May 14, 2021

**Re: Suncadia Phase 2 Division 6 - Nelson Ridge
Engineering Plan Submittal**

On behalf of New Suncadia, ESM Consulting Engineers, LLC is submitting this letter in response to your review letter we received on April 28, 2021 together with the revised construction plans. In an effort to provide concise and direct responses, we have copied the review comments below in *italics* and our responses are in **bold**.

NELSON RIDGE
ROAD/STORM DETAILS & NOTES

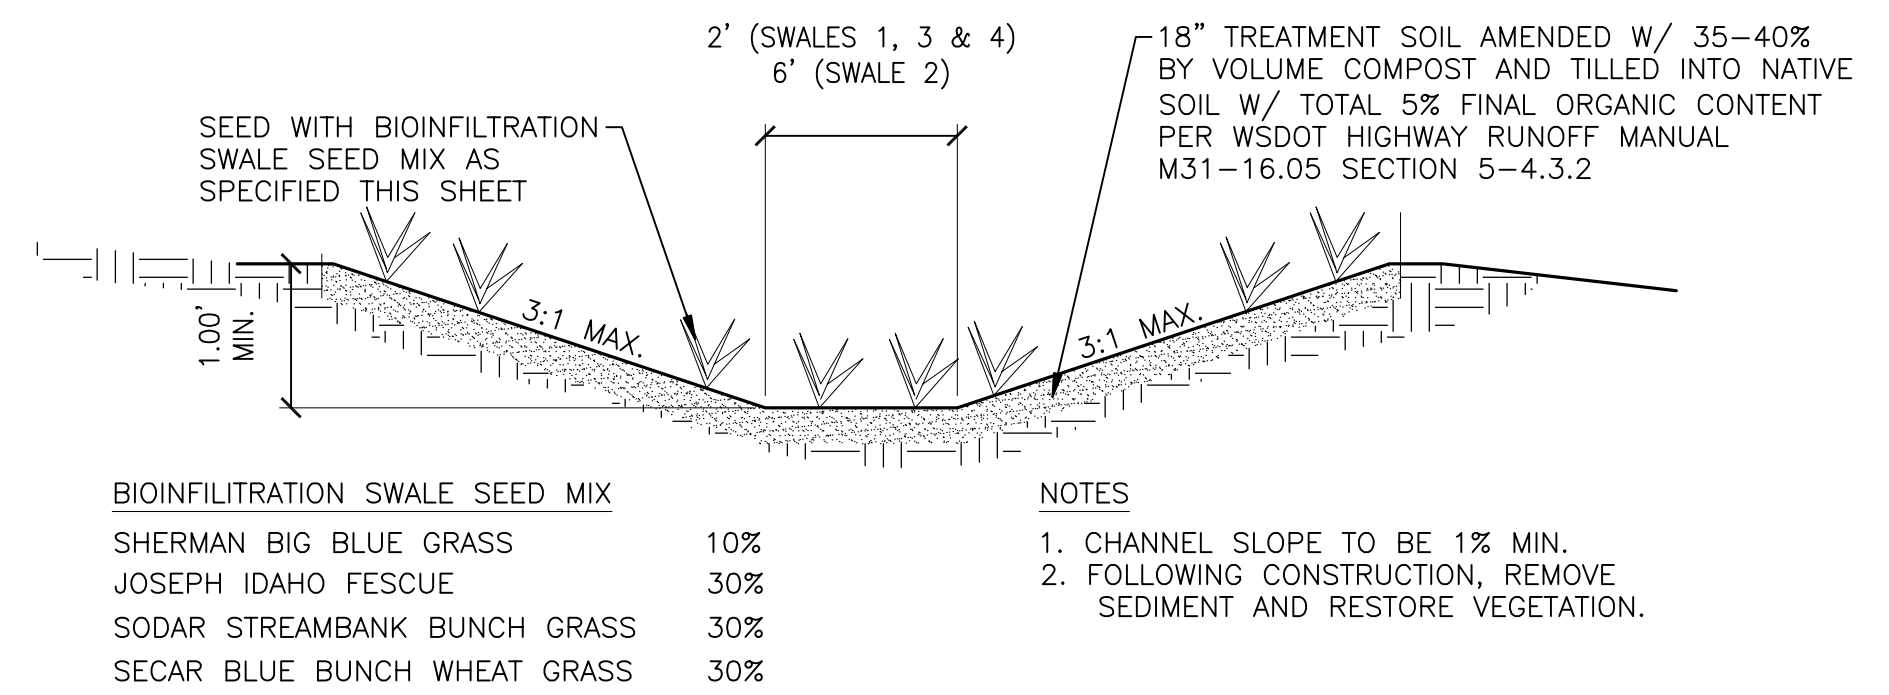
5. *The drainage report explains that SSC-6 will be met through amended soils. As in the previous submittal, please specify the approved soil on the plan set.*

Sheet DT-02 has been updated to reflect the engineered soil mix following the requirements of the SSC-6 in the Stormwater Manual. The engineered soil mix is proposed to contain compost and organic content as recommended in the WSDOT Highway Runoff Manual M31-16.05 Section 5-4.3.2 Soil Amendments.

NEW SUNCADIA, LLC
 NELSON RIDGE
 ROAD/STORM DETAILS & NOTES

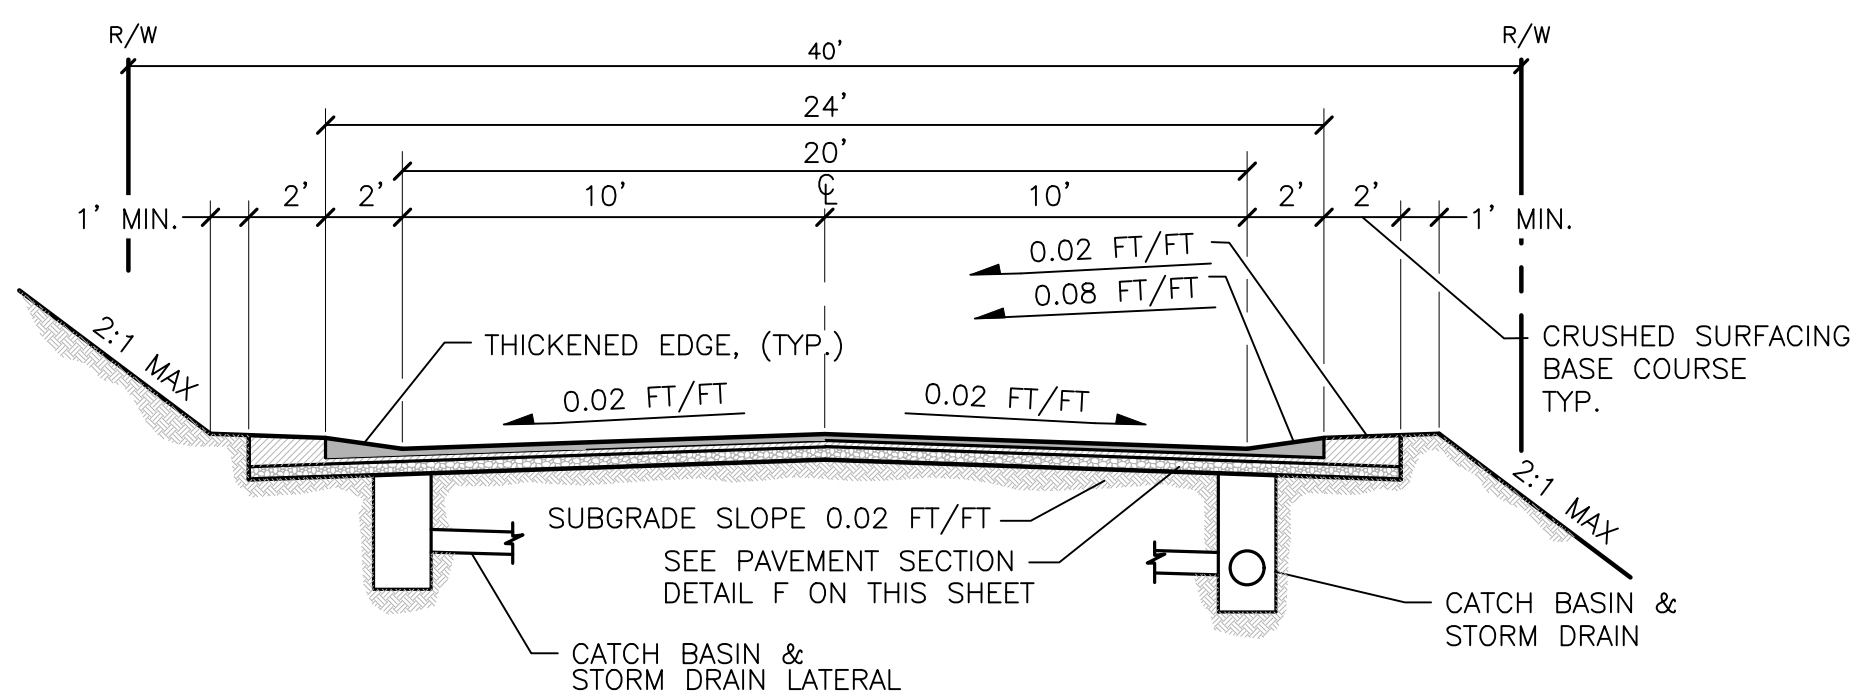
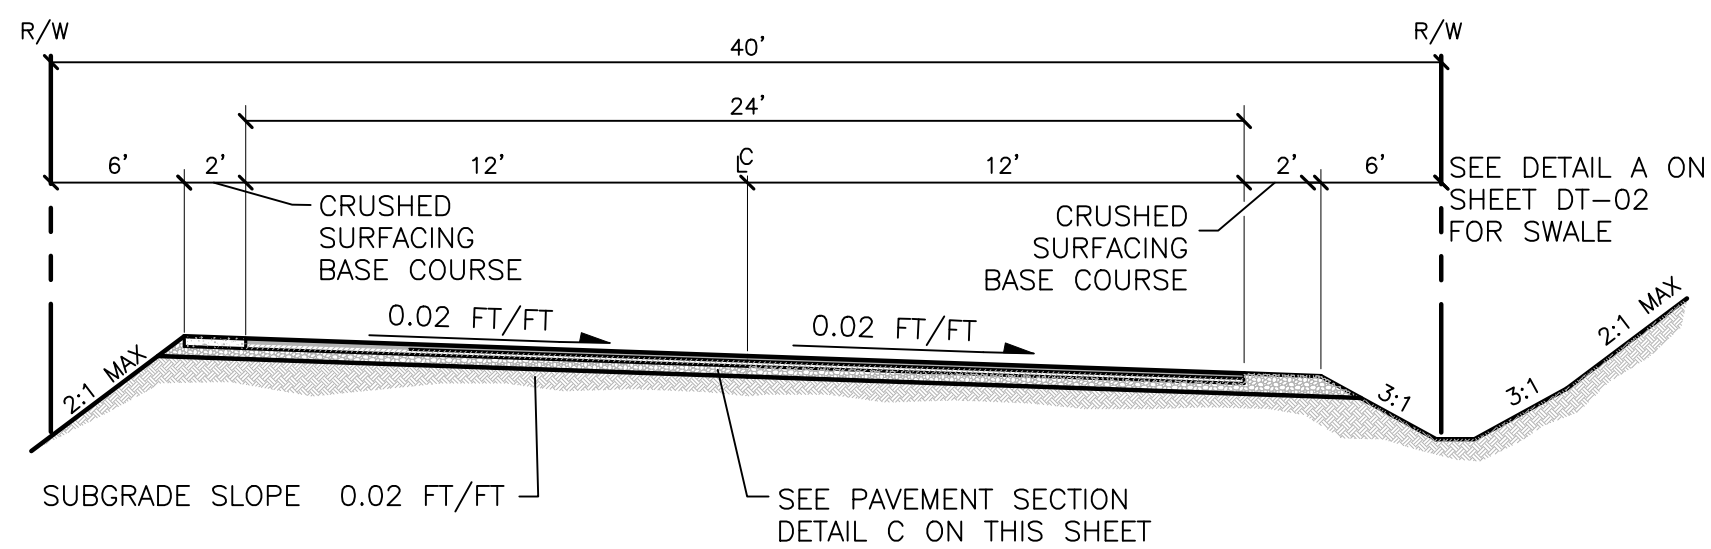
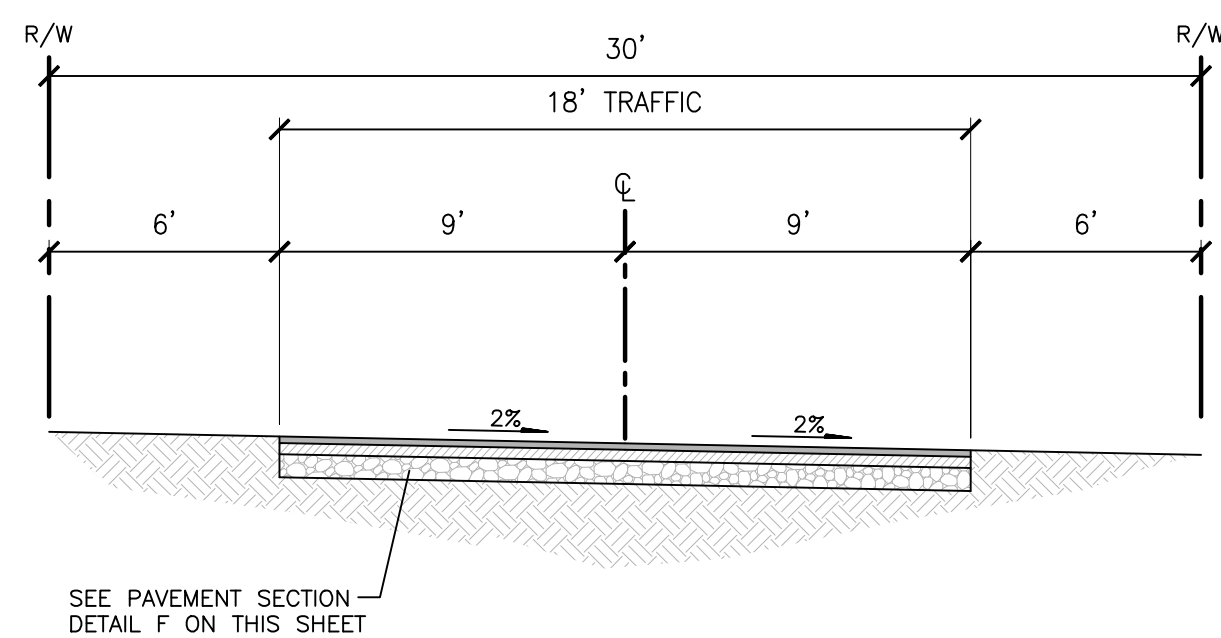
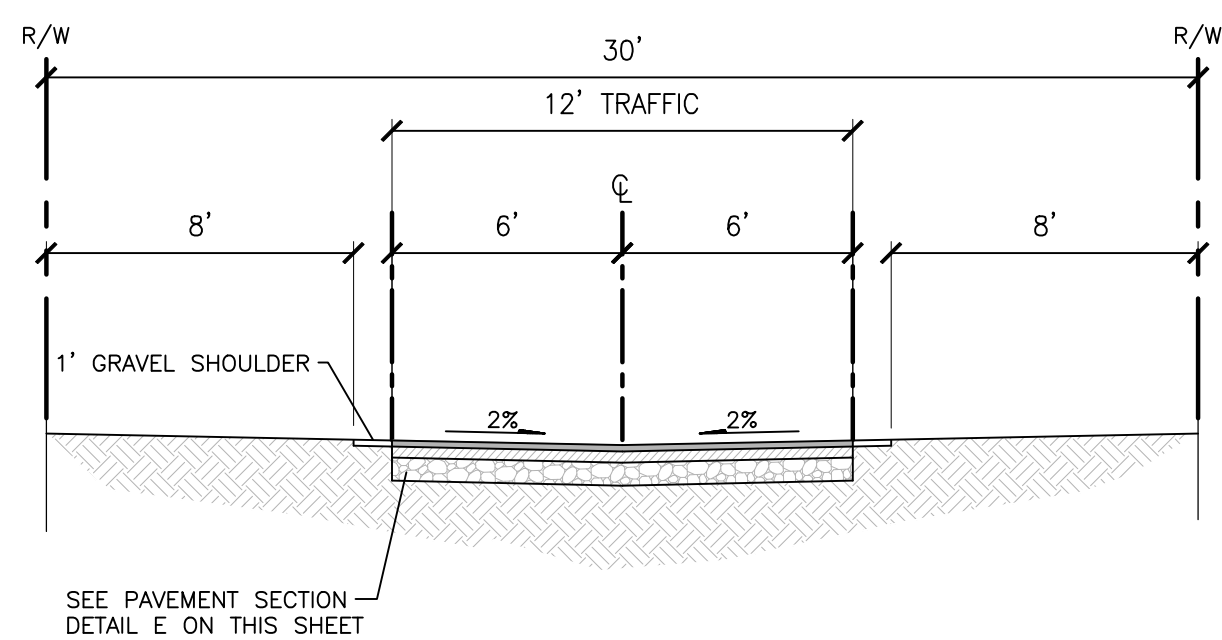
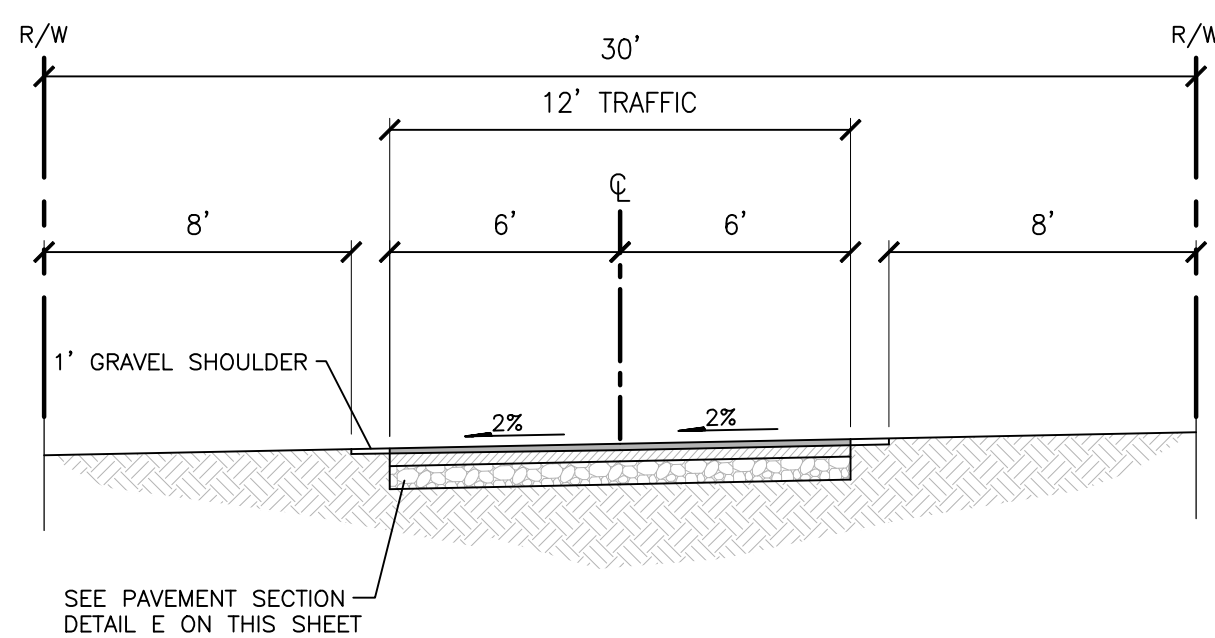
4. *Please provide a cross section of the proposed roadway system.*

The cross-section has been added to sheet DT-03.

H DISPERSION TRENCH
NOT TO SCALE

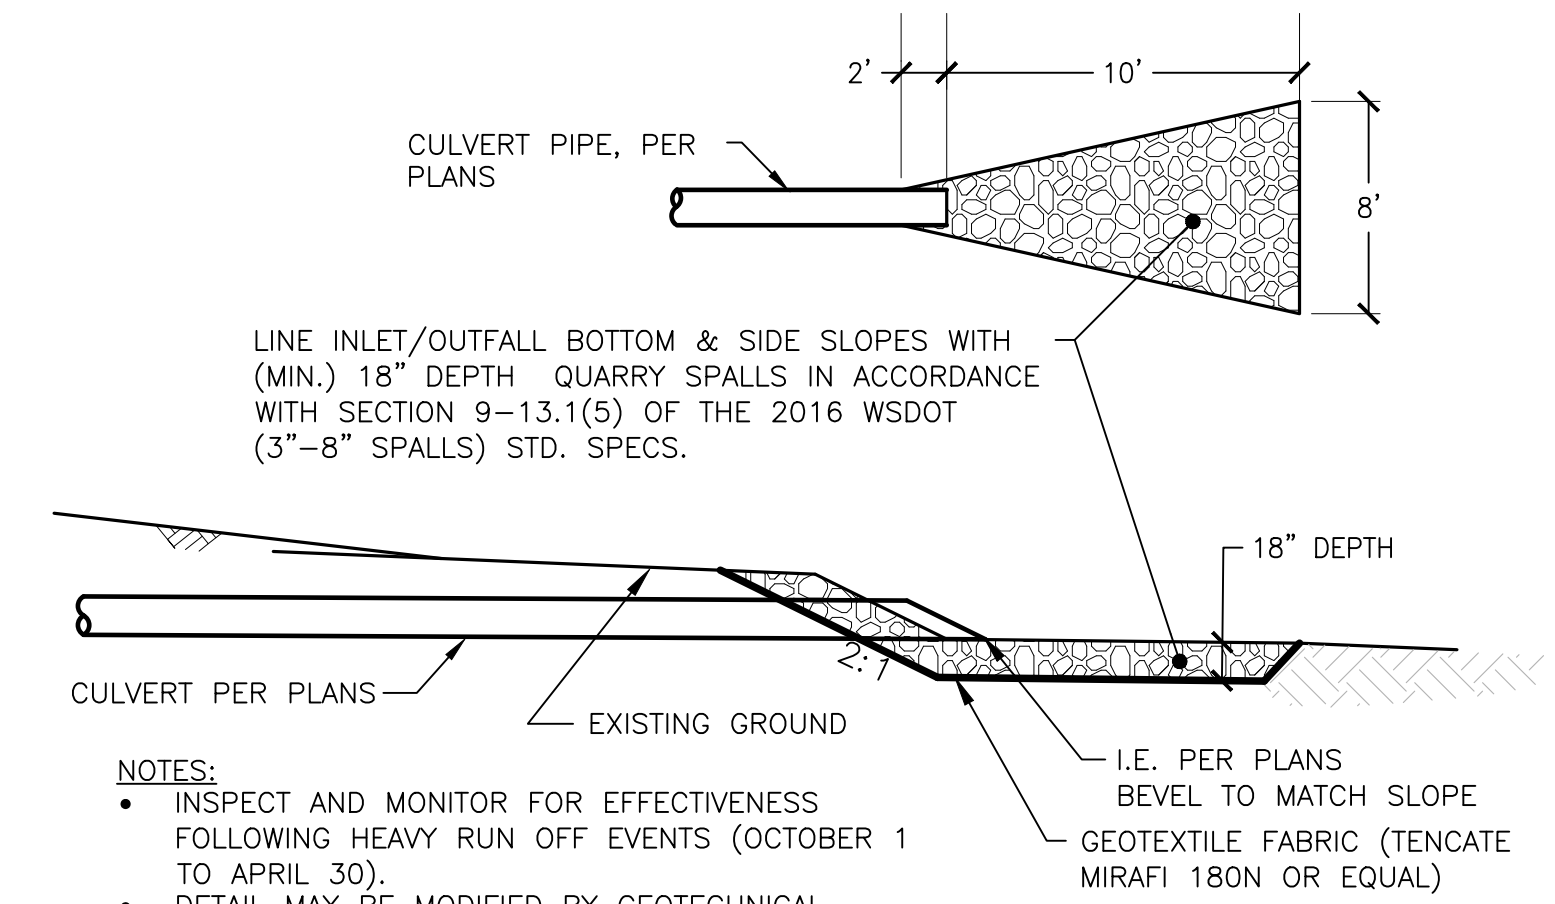
- 2. The drainage report shows that Swale 1 seems to be under sized. For the design storm shown, the swale operates with 0 free board and still overflows into a dispersion device. The report claims that the existing Basin D discharges at a flow rate of 0.543 CFS, but existing conditions do not contain any conveyance systems so existing conditions aren't discharged through a single point. The plans do show a gravel dispersion trench and an overflow spillway, was there any analysis done to verify this solution.*

The available infiltration rate for the location of Swale 1 is 1.08 inches per hour, which allows for the majority of the flows to be infiltrated in the bio-retention swale (0.273 - 0.105 = 0.168 infiltrated at peak flow). The remaining 0.105 cfs is discharged to a 20 feet wide dispersion trench which then has a 100 feet flow path. Dispersion

trenches typically allow for 0.10 cfs per 10 feet of dispersion trench width up to 0.5 cfs, so we believe the proposed design meets requirements with a factor of safety that would allow up to 0.2 cfs to be dispersed in the proposed dispersion trench.
